Subject: IOZ Design Review – 22 Bramhall (Maine Medical)
Written by: Caitlin Cameron, Urban Designer
Date of Review: Monday, March 5 2018

Below is a summary of Planning Board comments from the February 27th workshop regarding the projects at 22 Bramhall Street – East Tower and Visitor Garage expansion. These two projects are reviewed according to the adopted IOZ IDP and Regulatory Framework standards.

Visitor Garage Expansion

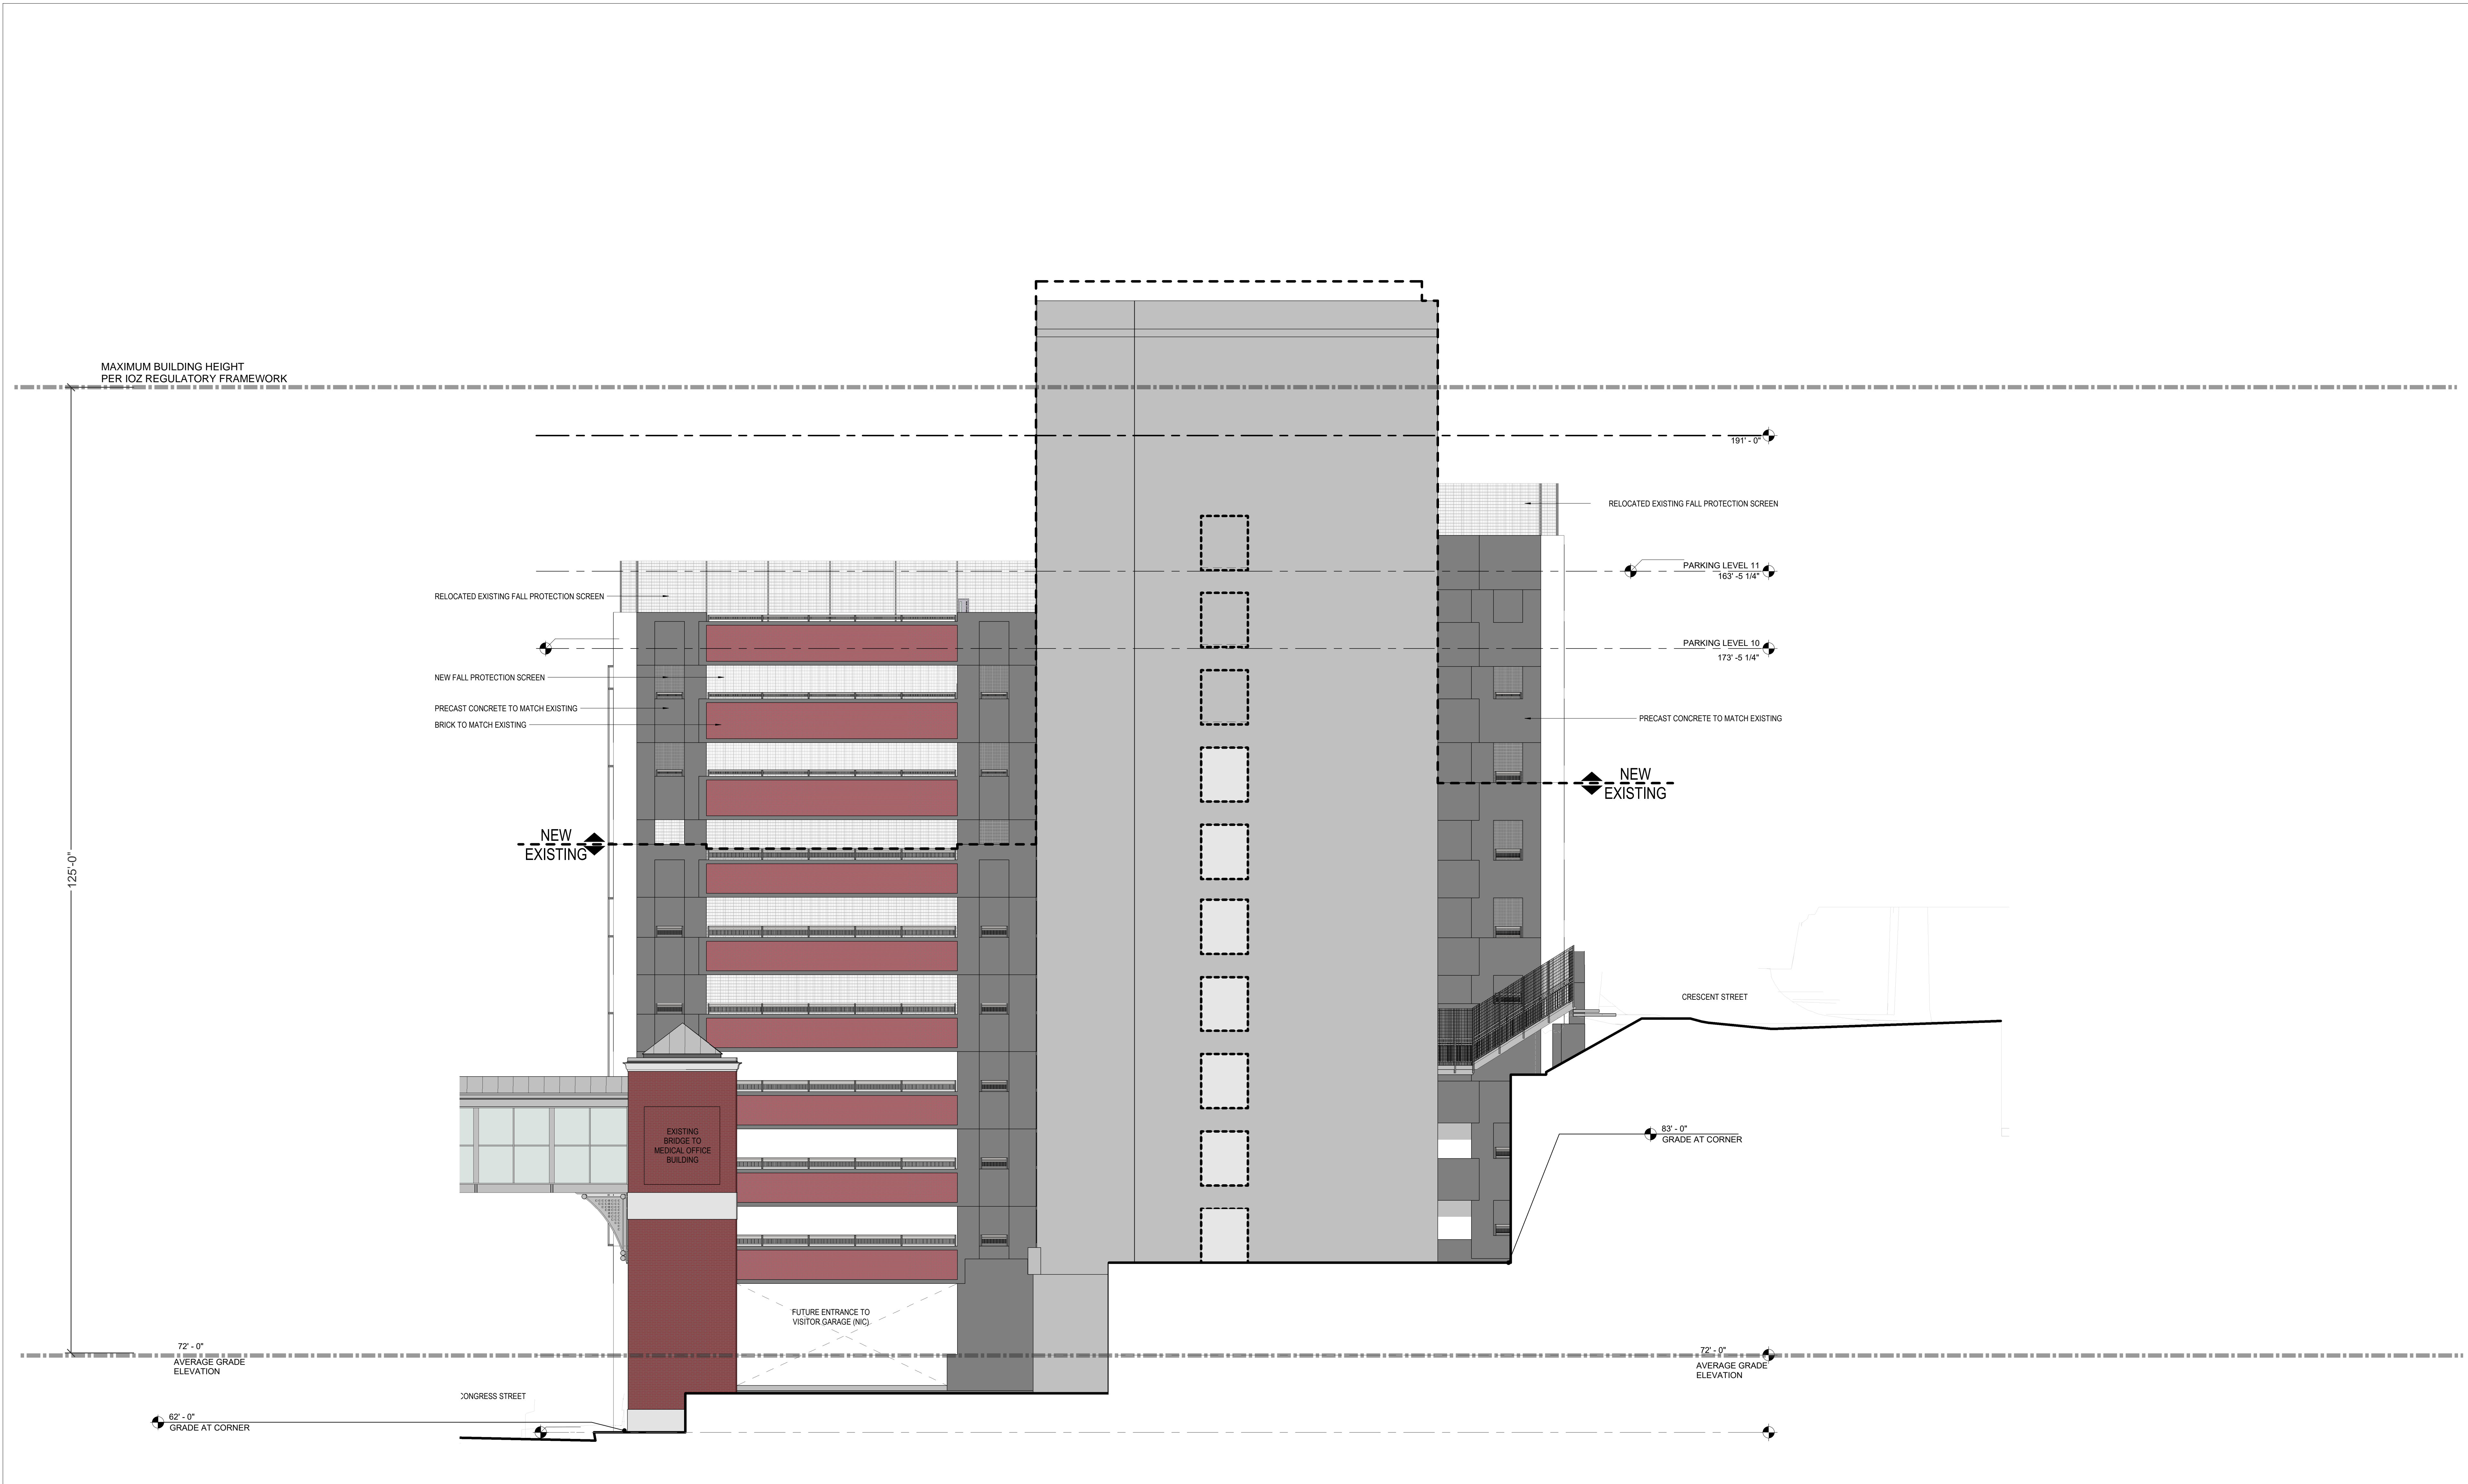
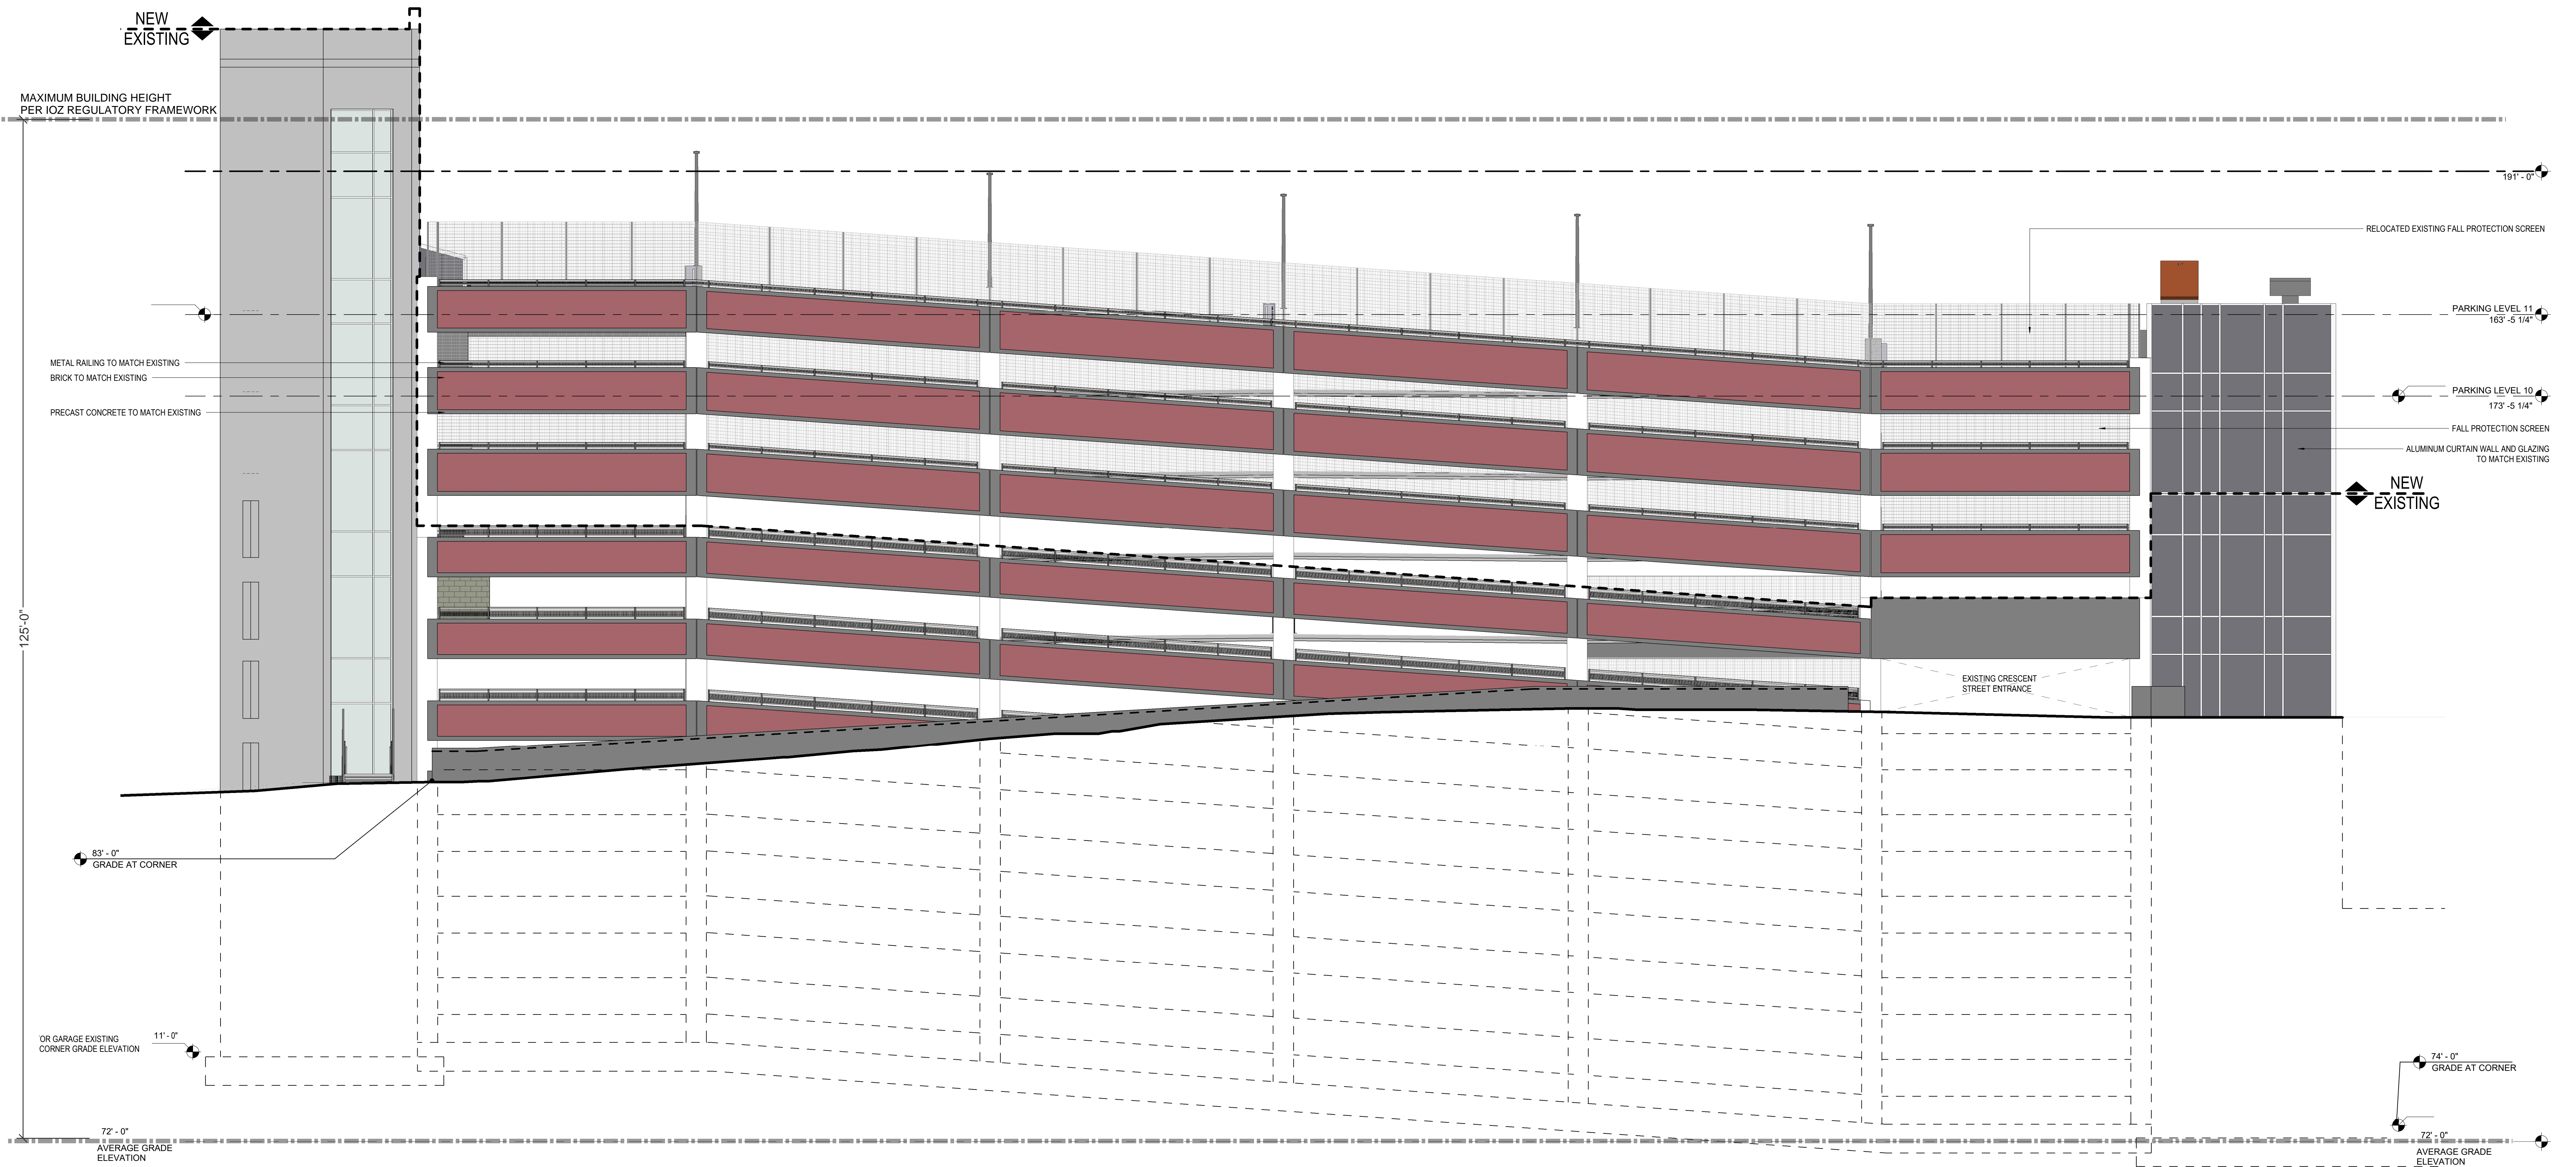
Visitor Garage: The proposal maintains the existing material palette of brick, concrete, and metal screen. **Planning Board is concerned about the prominence of the garage on Congress Street and the lack of visual interest and contribution to the public realm by using the existing material palette.**

Visitor Garage: **Congress Street is a major street and this building will become even more visible from long views as it grows in height. The garage proposal lacks visual interest from long views – articulation and visual interest are important for the garage in the forefront of the campus. Planning Board asks that the applicant re-evaluate the approach. Although staff and Planning Board acknowledge it is not realistic to completely redo the siding of the garage, consider options like adding decoration to give three-dimensional life to the façade, laser cut metal panel. The roofline is an element where visual interest could be added - Planning Board commented that the simple roof form does not have enough visual interest for the long views.**

Visitor Garage: Screening requirement is met - Screening methods will follow the established existing design – solid wall with metal mesh railing with a trellis accent – this current condition successfully screens cars/headlights from Congress and Crescent streets. **Planning Board commented on the lack of visual interest on upper floors and feel this guideline is not met – roofline, façade material, fall protection/screen design are possible architectural elements that can address this guideline.** Street activation guideline is met, see comments 7. above.

TITLE
BUILDING ELEVATIONS

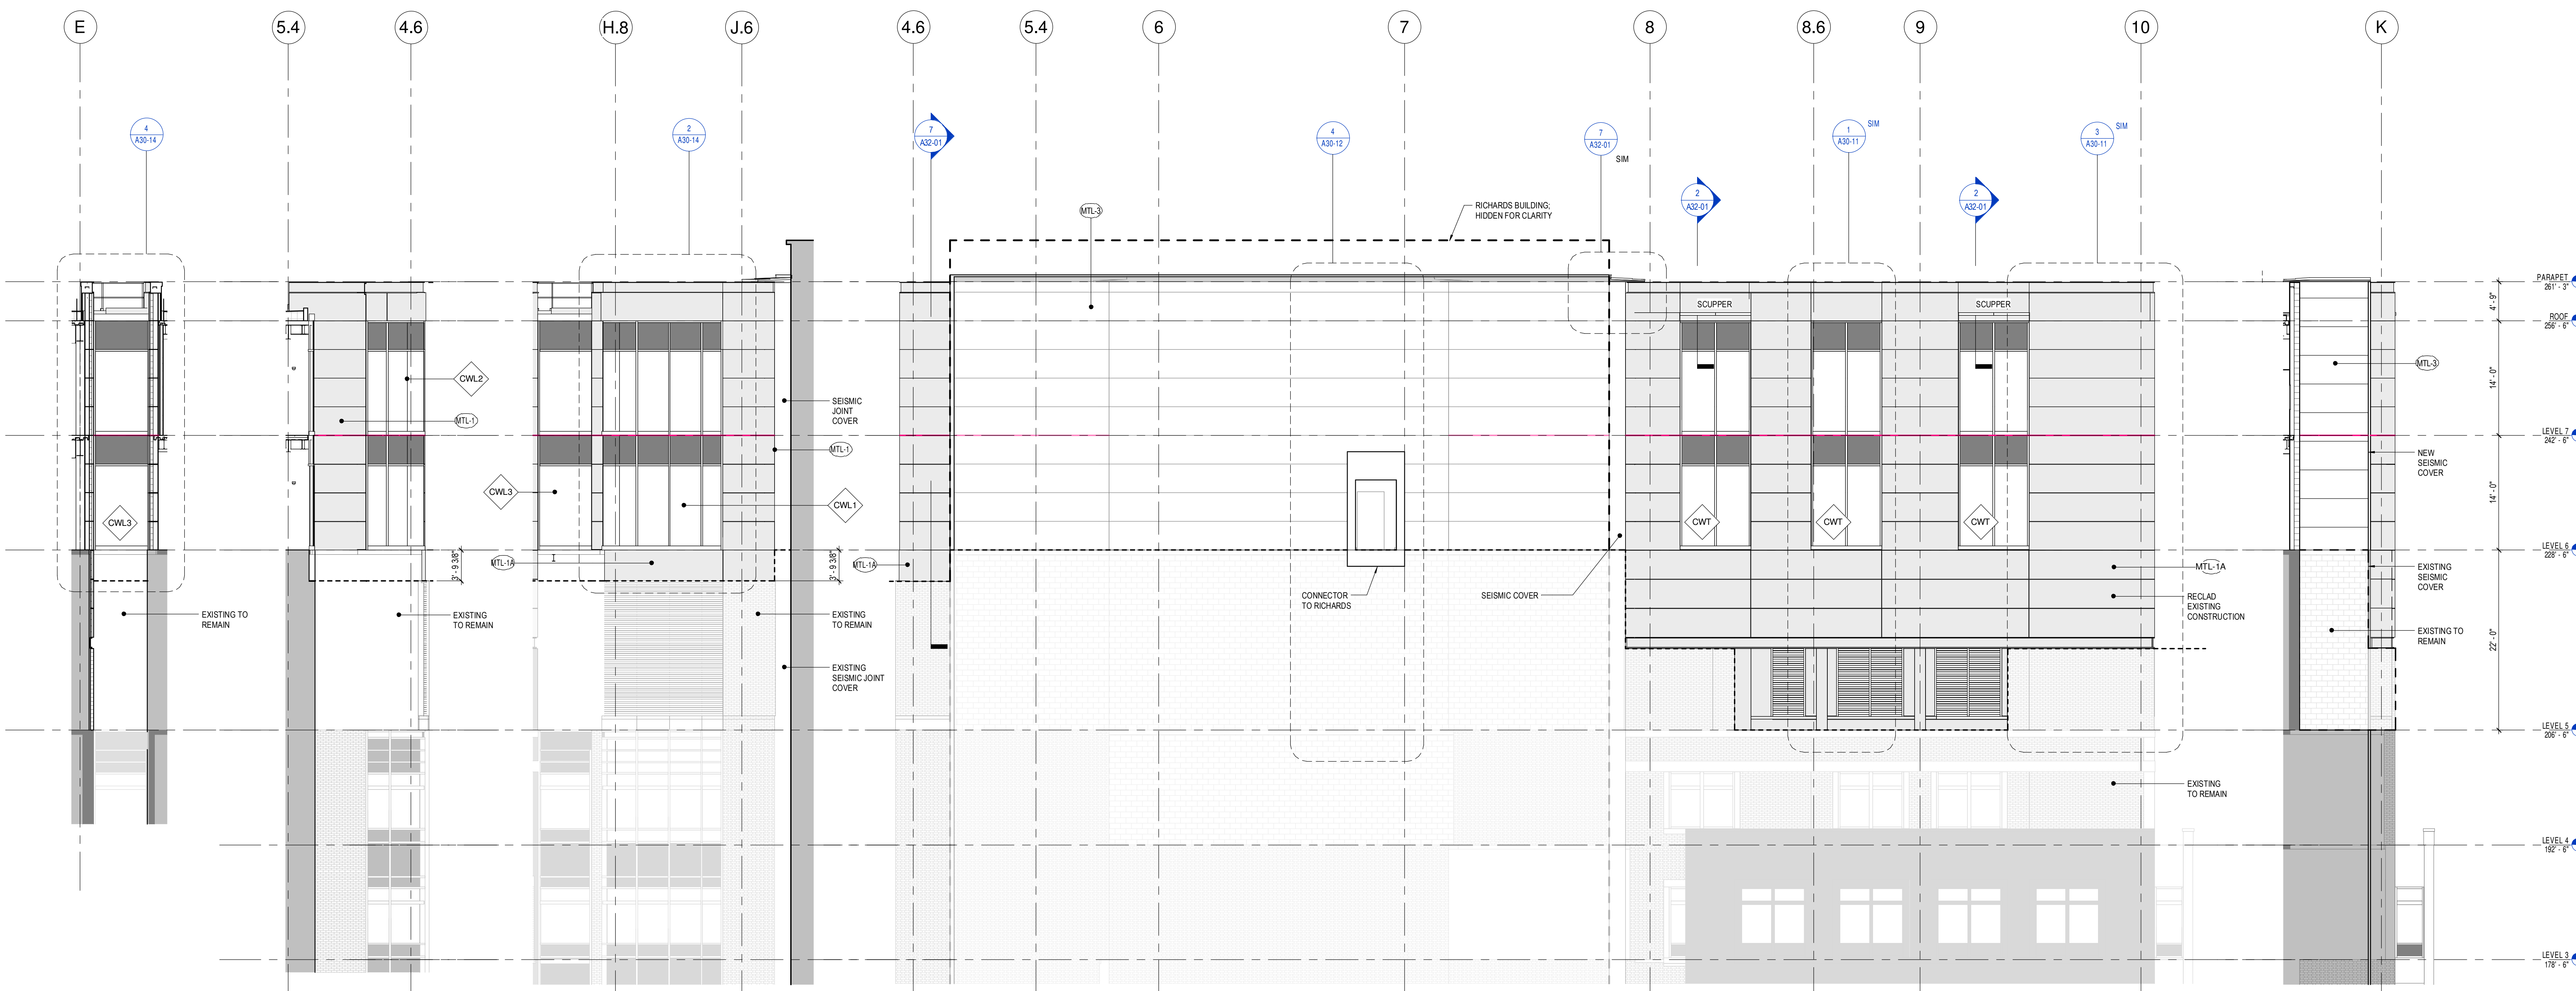
East Tower: **Some board members were concerned that the white panel will not achieve the desired effect of changing with the sky and natural light and therefore would not actually be recessive. There was additional comment on the white panel – members felt that the existing white elements in the campus design are not strong enough to take as inspiration for the new additions; why is a color that is a minor detail becoming a major design decision? White feels stark and while it may fit into a campus vision, there is concern about how this approach meets the guidelines regarding neighborhood integration/context. Finally, the board commented on the composition and proportion of the addition and commented that the design is lacking a base/middle/top which is a well-established approach to building design and façade composition.**

East Tower: The applicant indicated the material choices are limited by construction constraints as well as the existing material palette. The proposal is simple white metal panel intended to visually blend with the existing white materials as well as provide a light, recessive quality to the increase in mass and height. Visual interest will be provided by material pattern, fenestration, and shadow lines created by angled windows on each façade. **Planning Board continues to be concerned about the choice of white panel – concern is not for the quality but for the contribution to the public realm and appropriateness, especially as it relates to the long views and neighboring context.**

East Tower: **Planning Board commented that the simple roof form does not have enough visual interest for the long views.**
